Council Reference: DA10/0853.08 LN20960  
Your Reference:

**Additional TSC comments on the proposed amendments to the modification of the Cobaki Concept Approval (MP06\_0316 Mod 5) and the proposed modification of the Project Approval (MP08\_0200 Mod 4) with regard to water supply and waste water treatment.**

I refer to your emails of 15 March 2017 requesting Council's comments on proponent's response to Council's previous submission, in relation to the proposed Mods to the Concept Plan and Project Approval. Confirmation was also requested as to whether the latest documentation resolved Council's issues, following a meeting with the proponent.

Figure 5.9.1: Typical services section

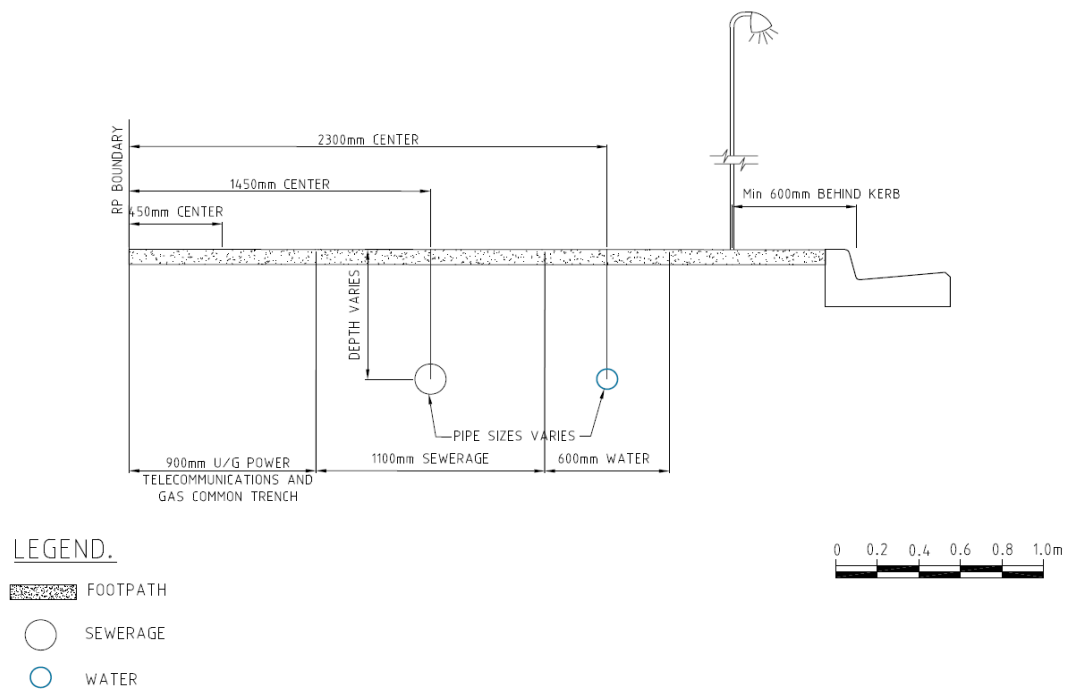
It is considered that the proposed deletion of **Section 5.9** from the Code would result in the development reverting to the road / footpath allocation in Council's Design Specifications (i.e. TSC Standard Drawing SD006). Such a scenario is not consistent with previous advice by the proponent, as to where they intend to place these services, nor does it clarify how the proponent intends to provide these essential services (i.e. water, sewer and recycled water) within the proposed road reserve. The questions previously raised by Council remain unanswered. As the future owners of the public road reserve, it is considered reasonable that such detail be provided and Section 5.9 of the Code remain.

As noted above, it is considered necessary to address the issue of infrastructure within the road reserve and as such, Section 5.9 of the Development Code should remain.

However, if the Department considers that Section 5.9 should be removed from the Code, then no objections are raised to the proposed changes to Control 5 (shown struck through).
